Memorandum

To: David Jaffe
From: Kelly Wilkinson
Date: 7/12/2017
Re: 2675 Mercer Way - Arborist Report - Revision

The most recent Arborist Report for this site was written on 8/16/2016. This memo is to address the 7/7/2017 comments from the City of Mercer Island.

NORTH
TREE REMOVAL PLAN
 SCALE: 1" = 10'-0"

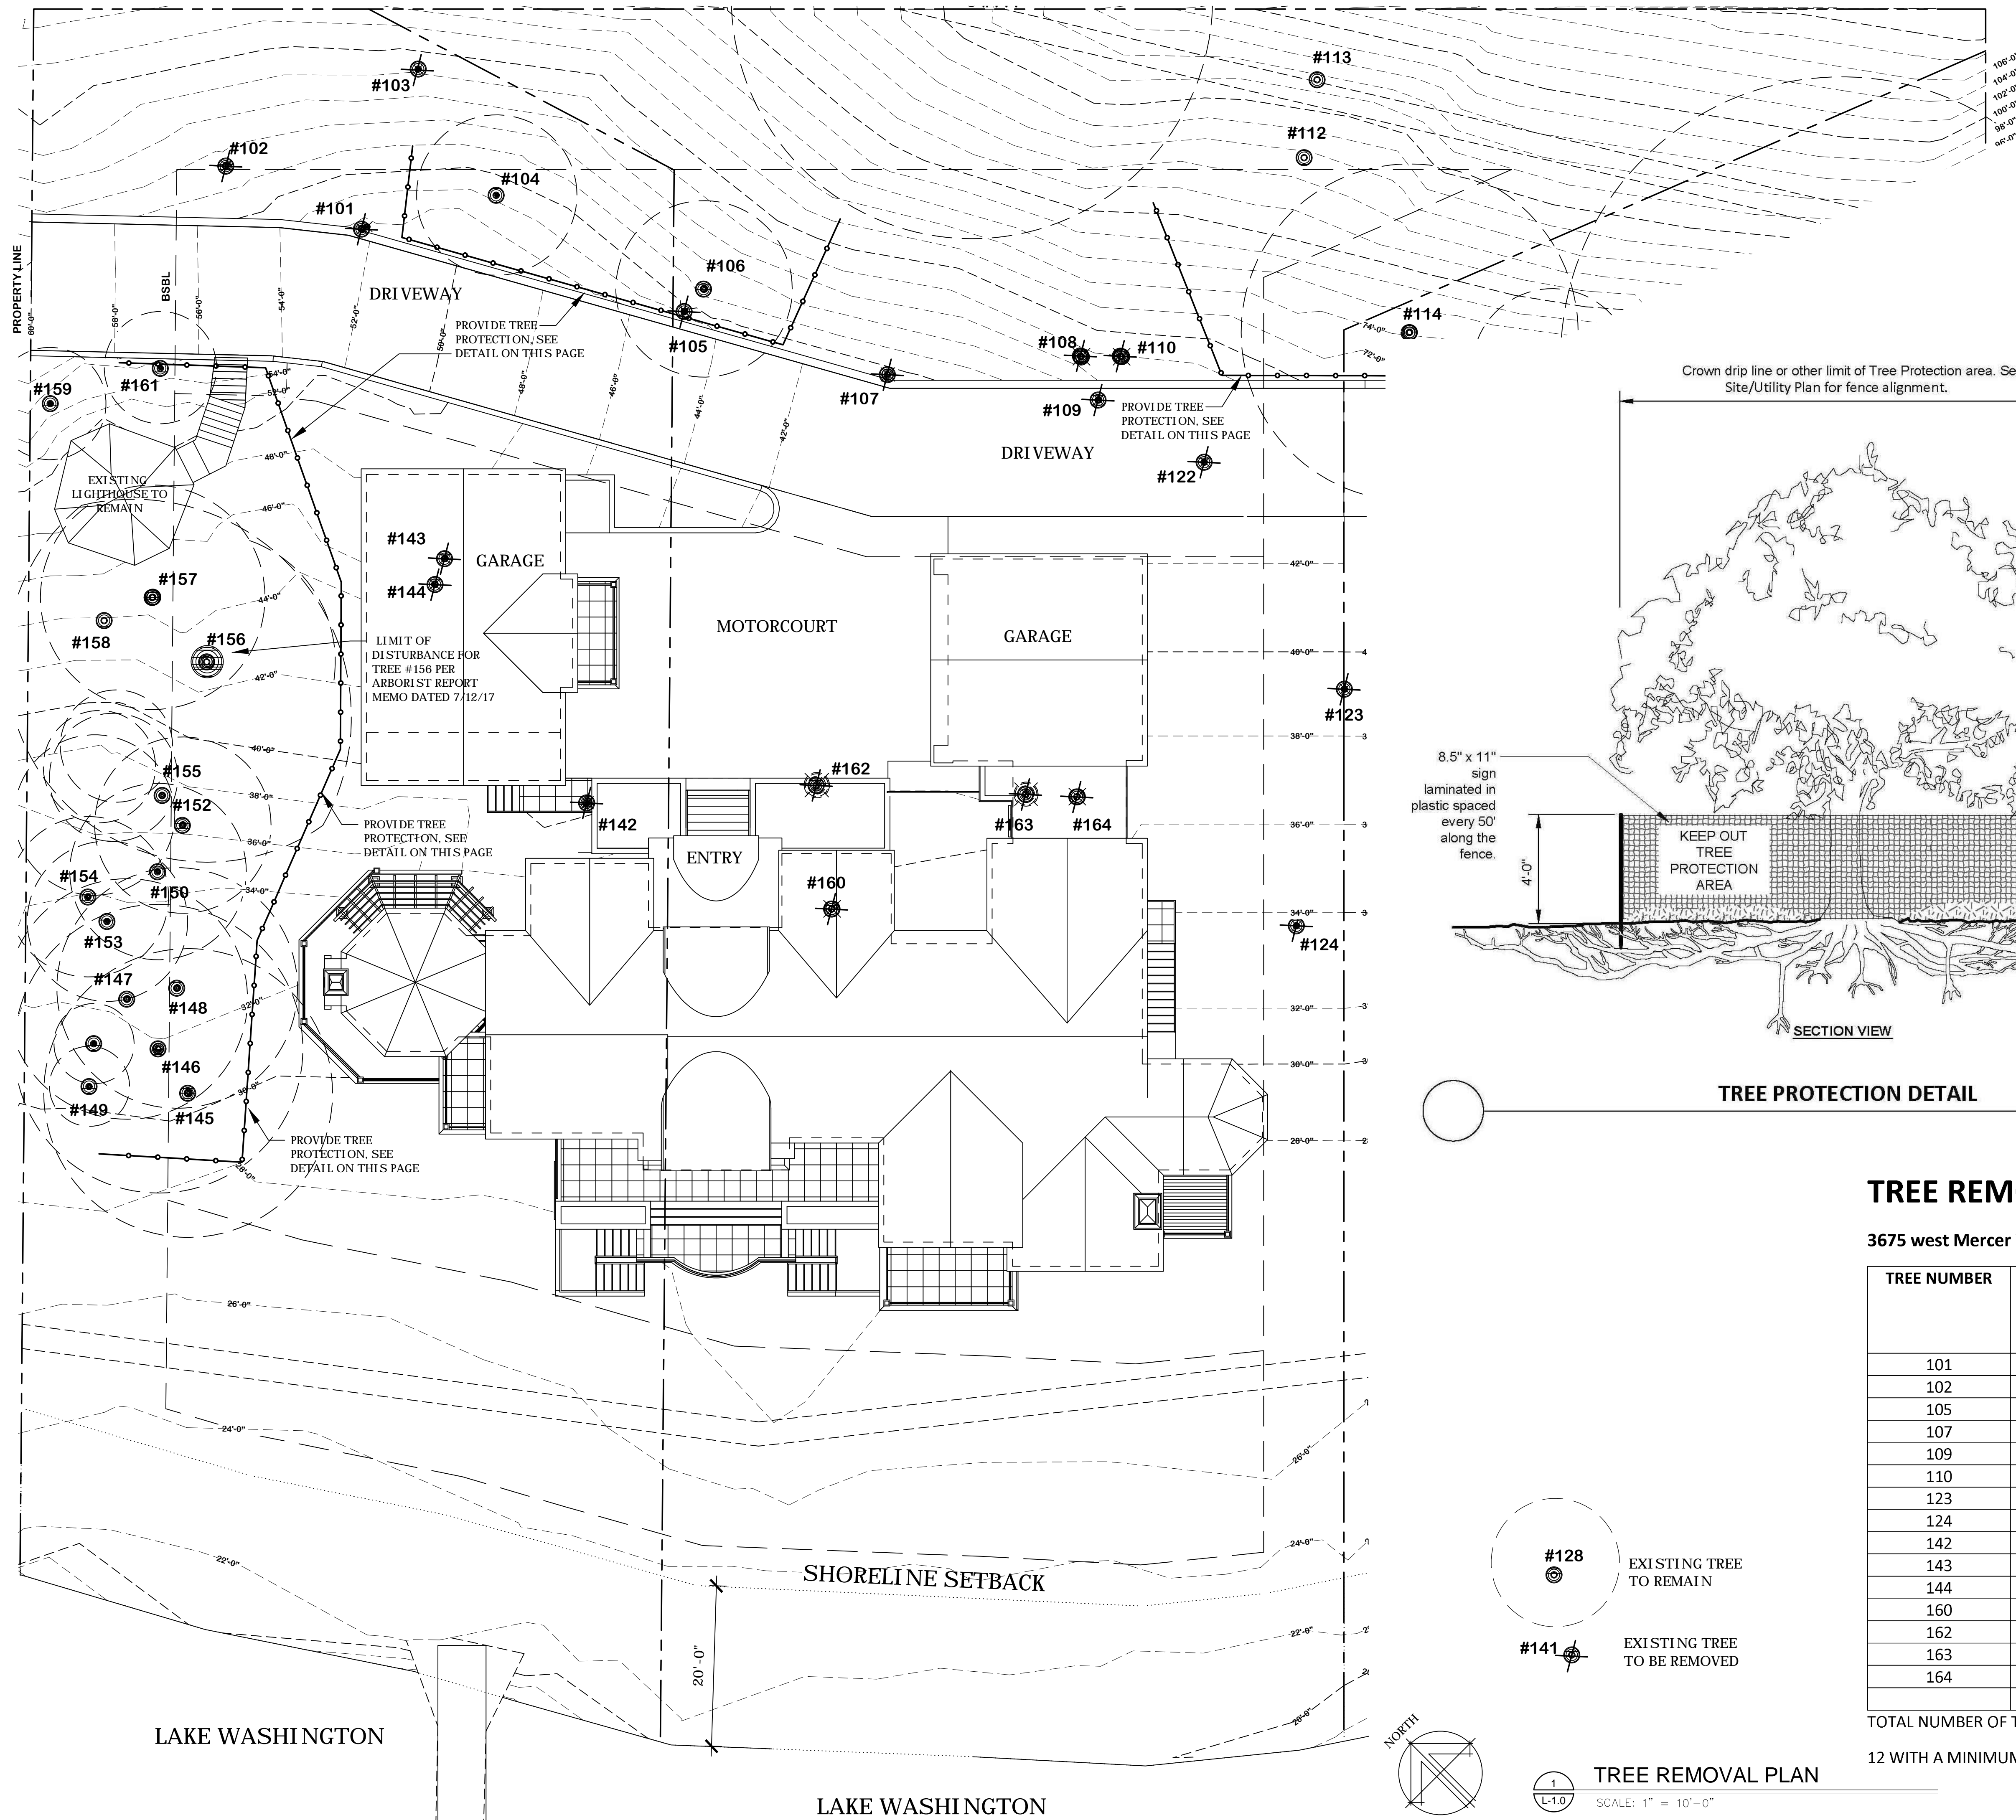
The City of Mercer Island is requesting the retention of tree #156, a mature Douglas fir tree. I have reviewed the site plans. Douglas fir is quite tolerant of some root loss and disturbance so long as the impact is kept to acceptable levels. The estimated total loss of root mass is estimated at less than 15% which is within the tolerable threshold. The continued retention of the subject tree is appropriate. I've adjusted the limits of disturbance for tree #156 to allow for the successful retention of this tree.

Drip-Line / Limits of Disturbance (feet)			
North	South	East	West
23 / 25	27 / 16	22 / 16	20 / 25

The plan is appropriate to preserve the subject trees in a viable condition; however, care will need to be taken when working near trees to avoid unnecessarily damaging roots. We can be available to assist in tree protection efforts when working near retained trees, particularly tree #156. If work is carried out diligently, all proposed retained trees are expected to remain viable.
